Application Ref:	3/2025/0284			 Ribble Valley Borough Council <hr/> www.ribblevalley.gov.uk
Date Inspected:	13/05/2025	Site Notice:	13/05/2025	
Officer:	MC			
DELEGATED ITEM FILE REPORT:				APPROVAL

Development Description:	Proposed alterations to vehicular access from Chipping Lane to include widening of access track, creation of pedestrian footpath and erection of fencing.
Site Address/Location:	Little Town Farm, Chipping Road, Thornley, PR3 2TB

Proposed Fence Detail

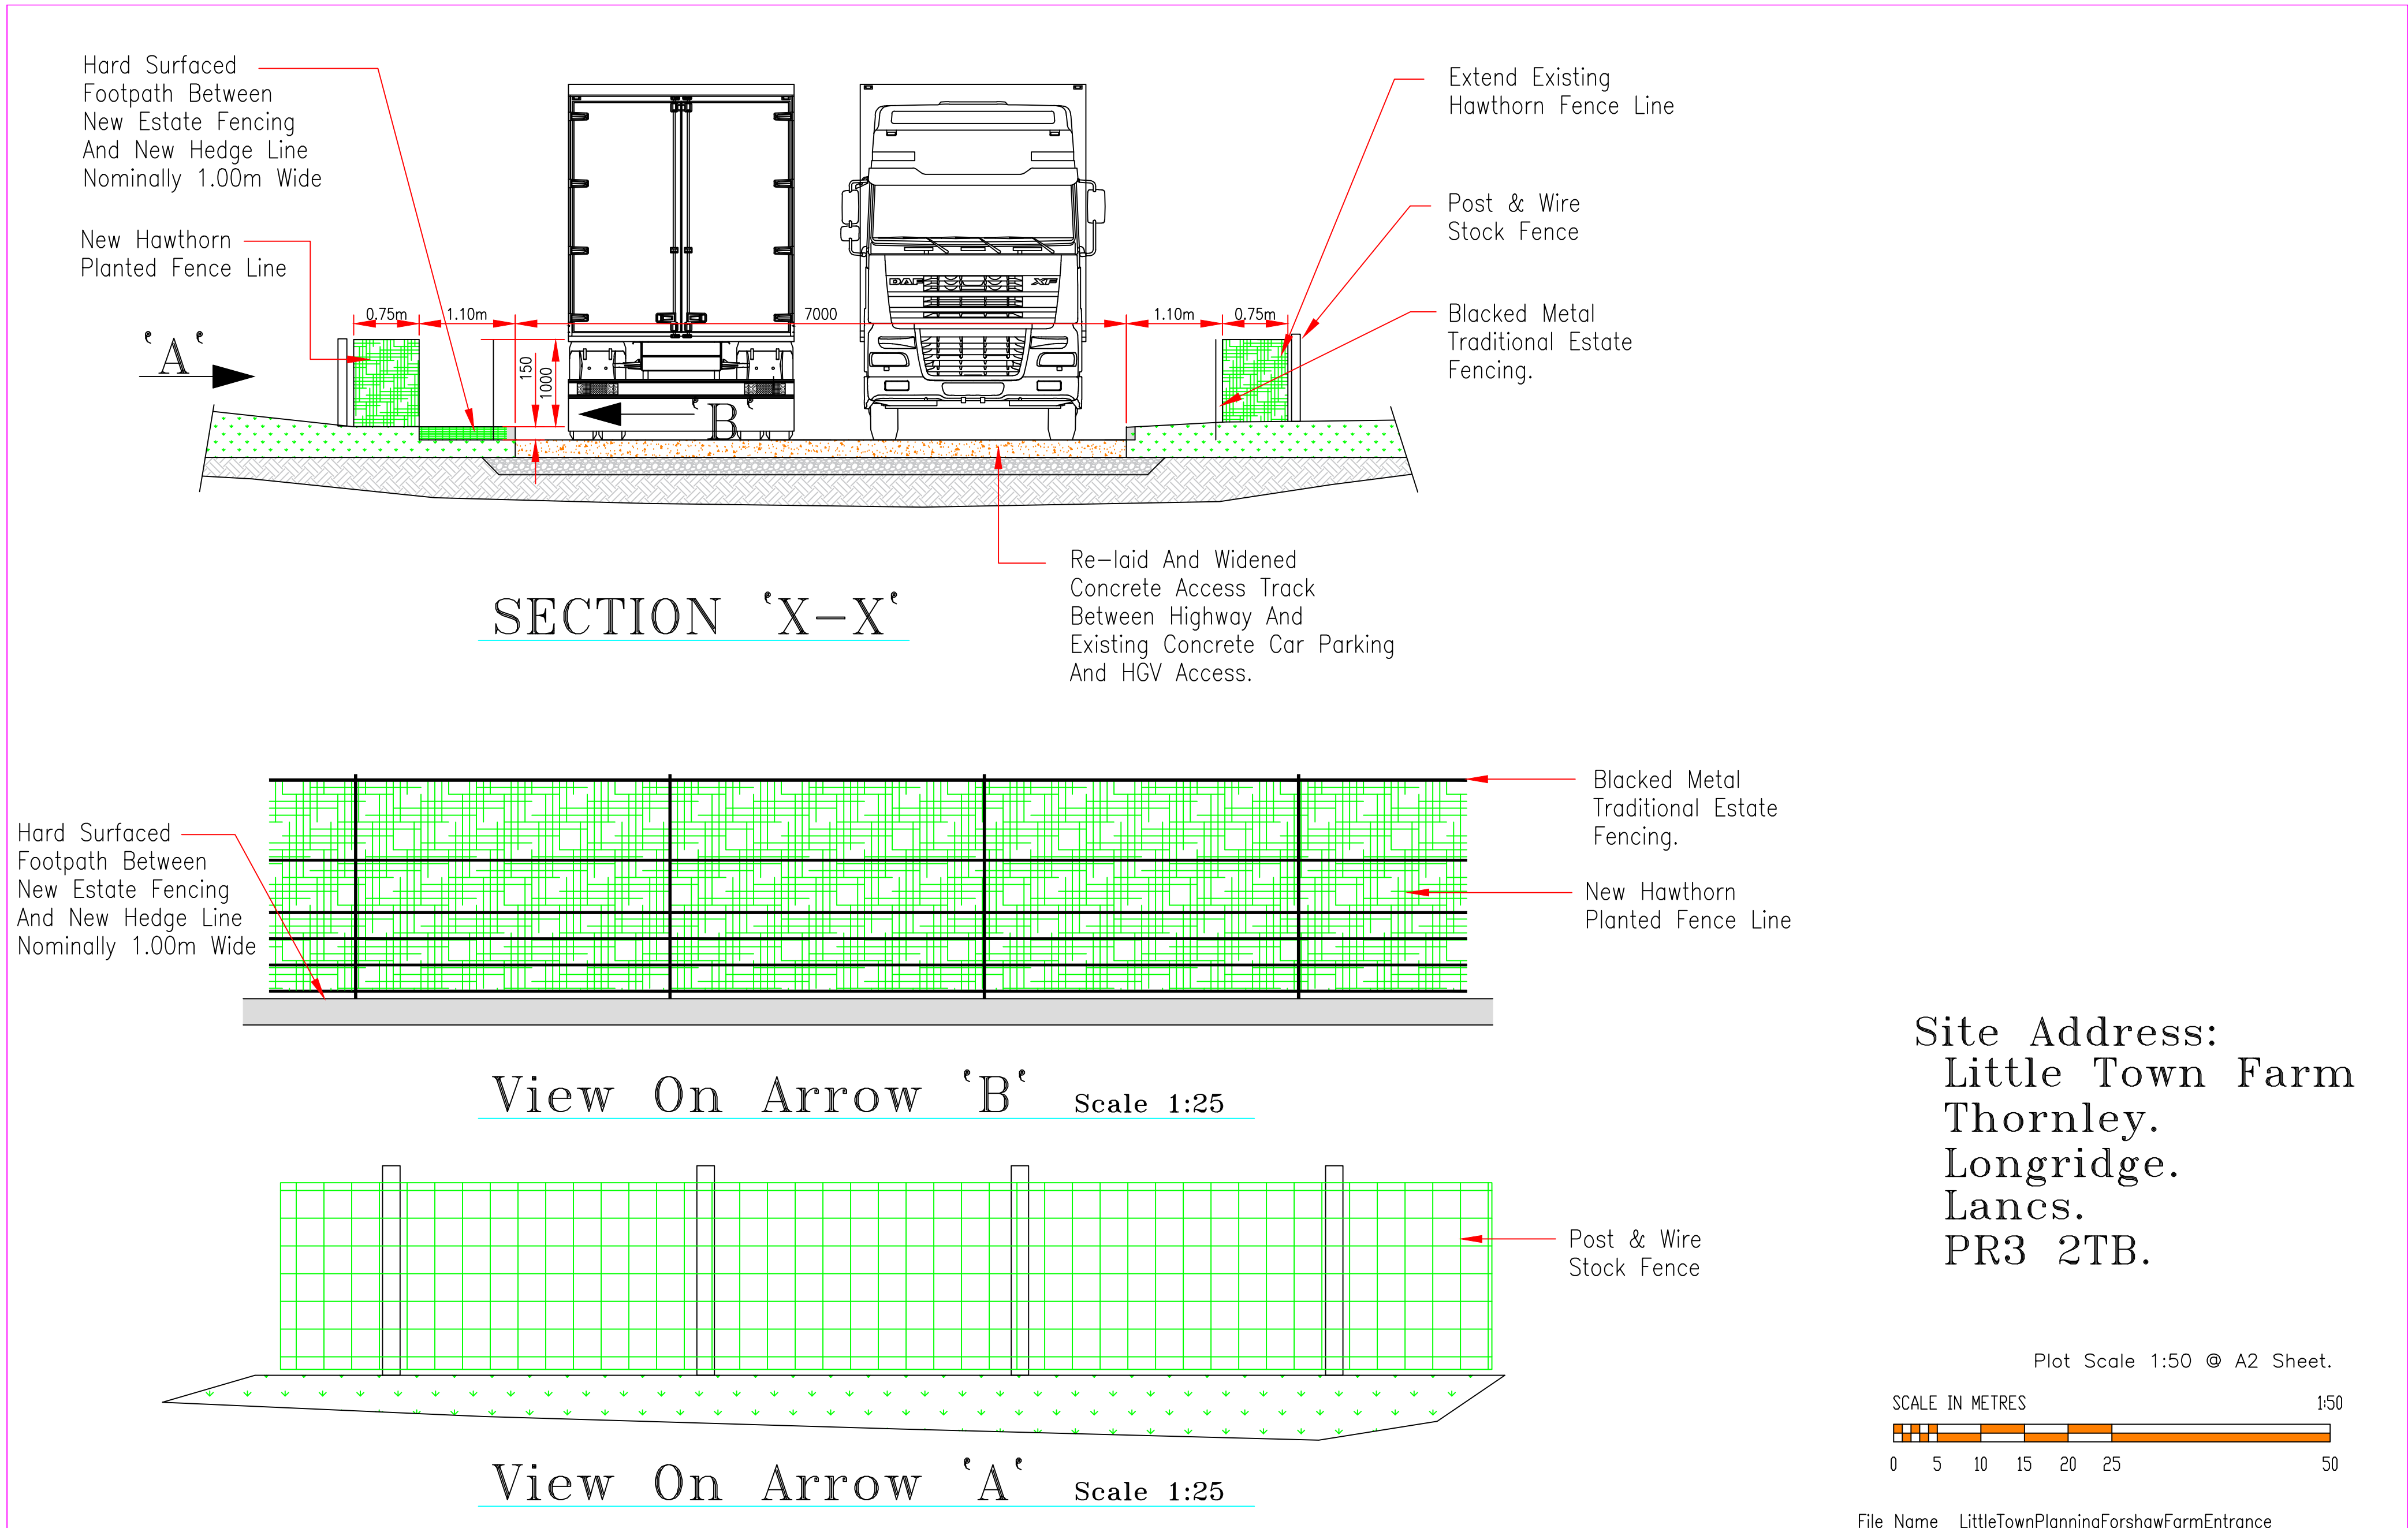
The proposal also includes the replacement of existing timber post and rail fencing with estate style fencing. The siting of which has been amended prior to the determination of the application to set the fencing back from the site frontage.

It is considered that whilst the development may change the visual appearance of the access to a more formalised access with additional hardstanding, fencing and boundary hedgerow, the fencing would now be set back from the road frontage which would help to reduce the visual impact. The LPA could impose a planning condition to ensure the details of hard surfacing materials are provided as part of a landscaping plan.

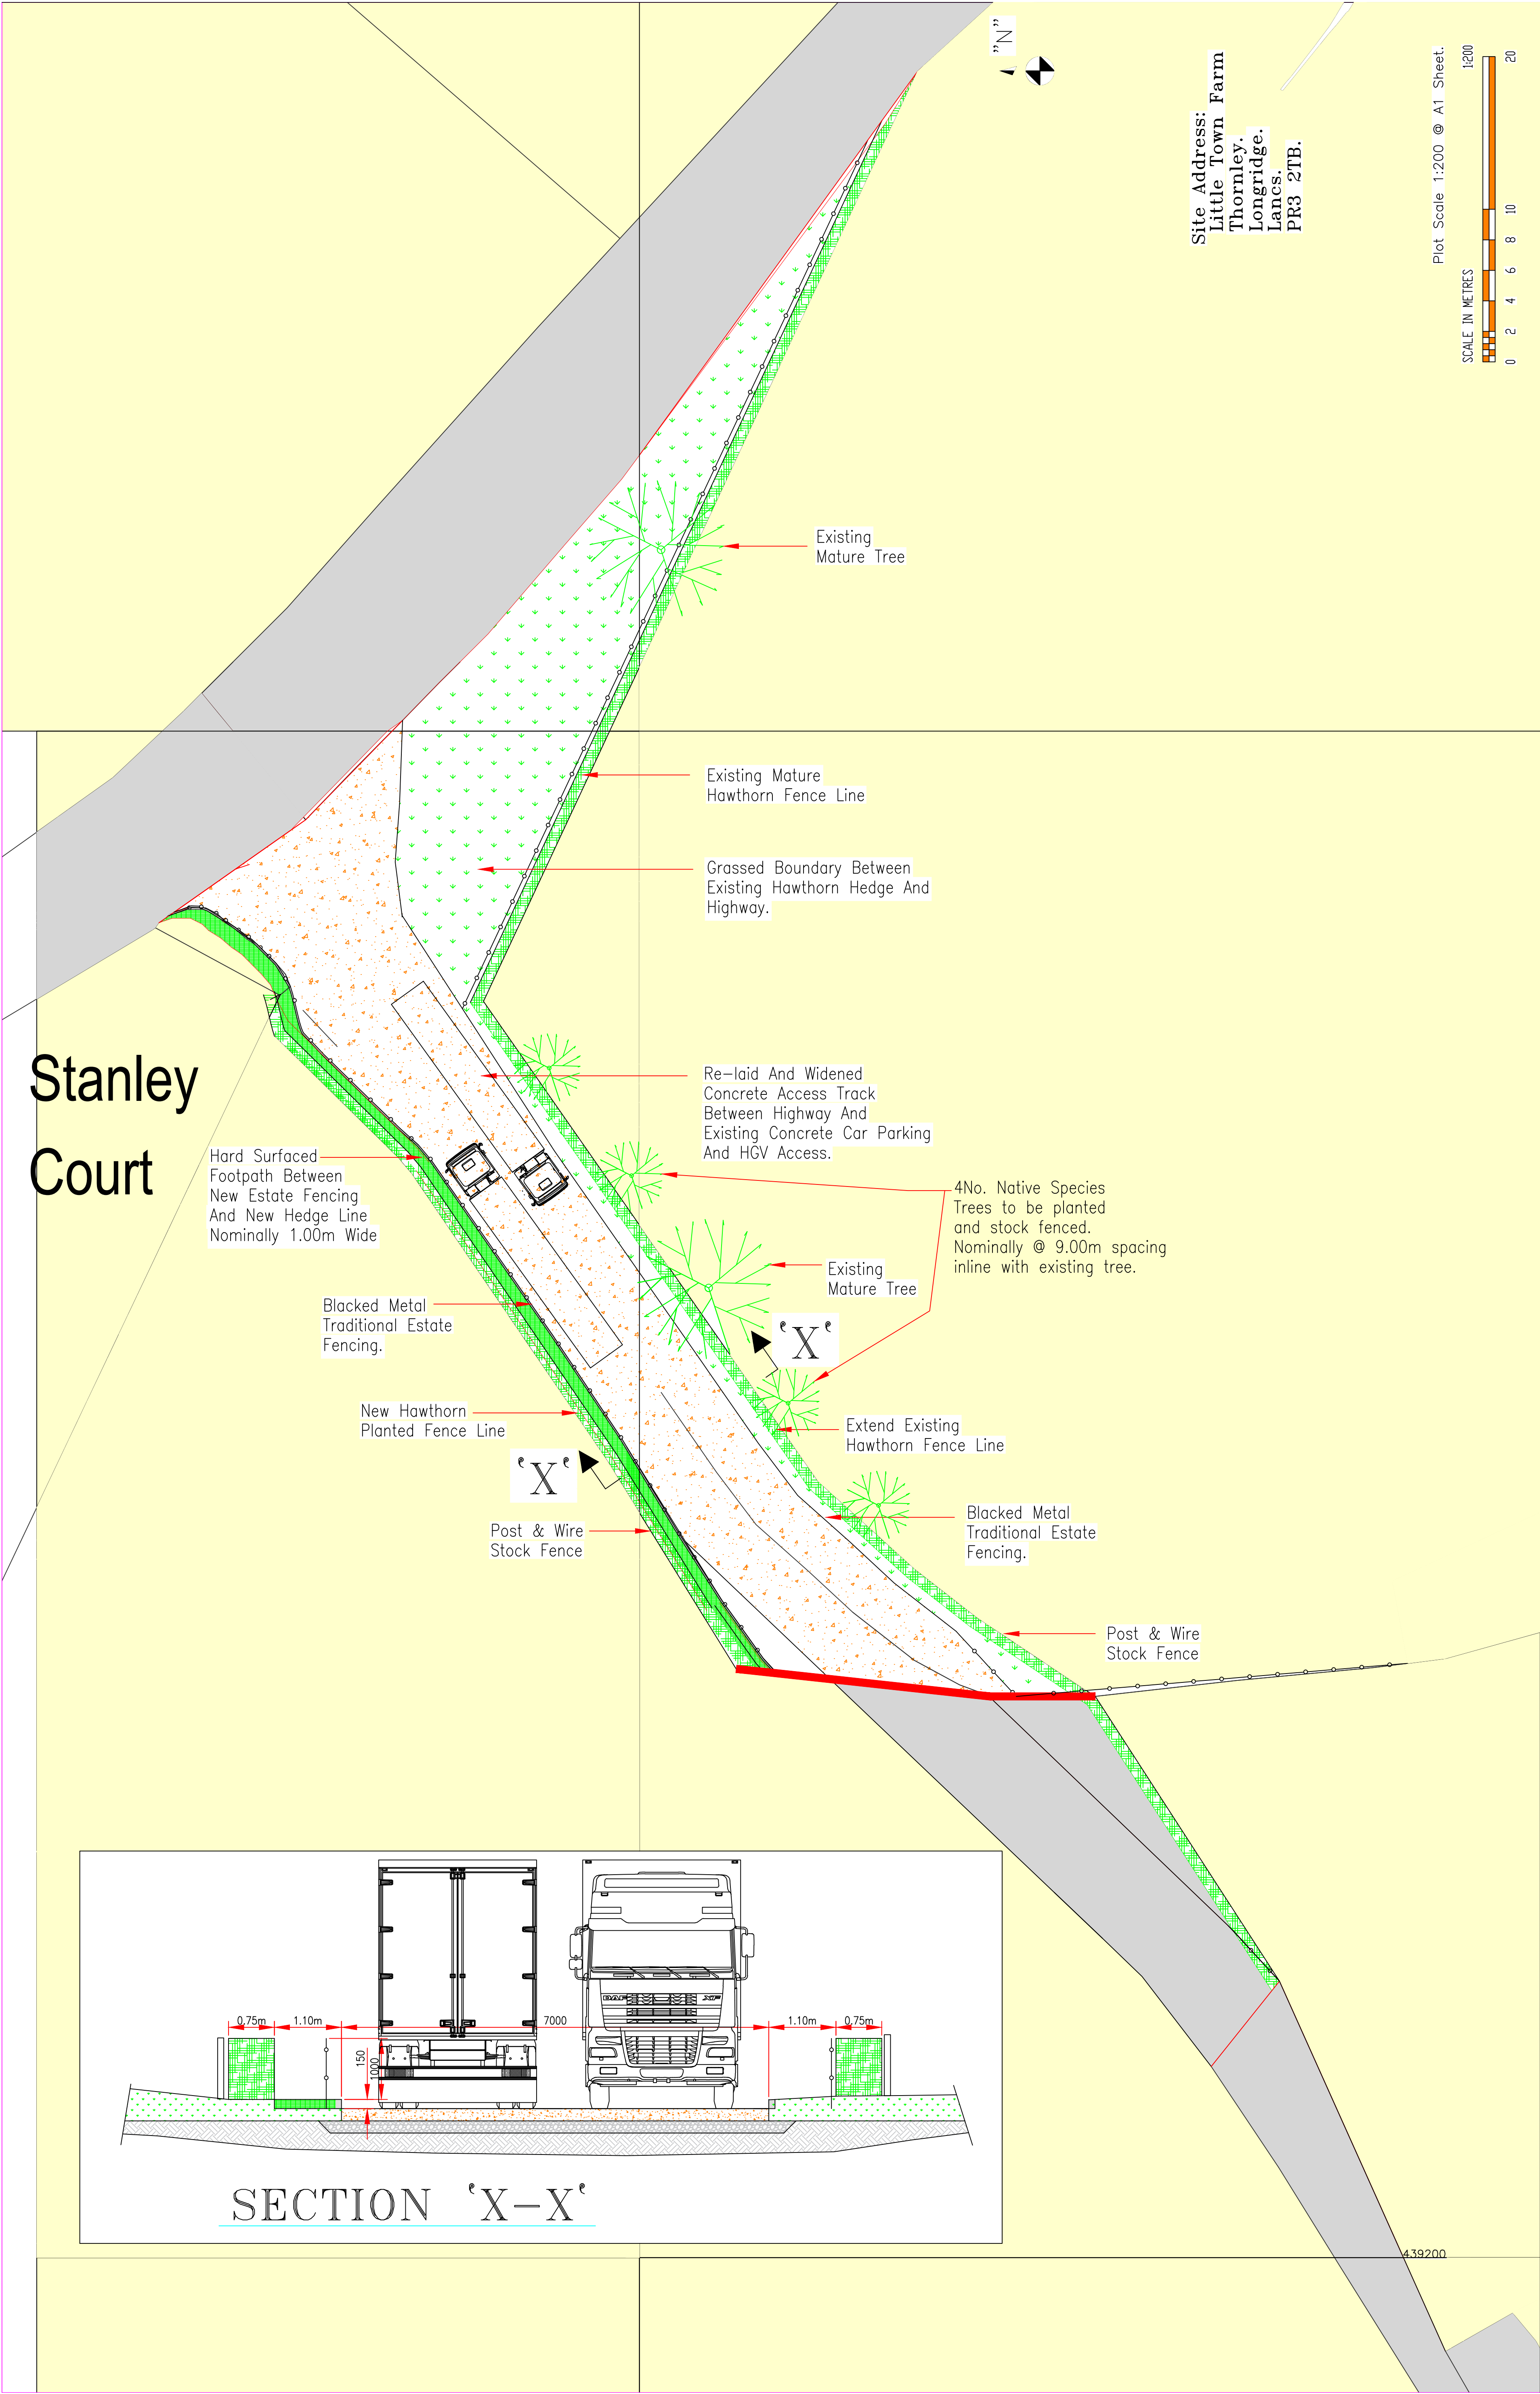
The Local Highway Authority (LHA) originally objected to the proposed development and requested that the applicant provide details of parking/turning for HGV’s as well as widening the proposed pedestrian footpath so that it complies with accessibility standards for wheelchair users.

The Public Rights of Way Officer has objected to the development as they consider the footpath should be widened to a minimum of 2m to meet mobility guidelines for wheelchair users and they also include conditions requiring the applicant to divert the Public Right of Way (PROW) prior to the commencement of development.

The LPA consider that the diversion of the PROW is dealt with under separate legislation and as such, the conditions would not be reasonable. It is considered that whilst there would be a benefit to increase the width of the pedestrian footpath to 2m, the proposal to create a 1m wide dedicated footway would be an improvement on the current situation. Moreover the existing track would still be available to use if required.
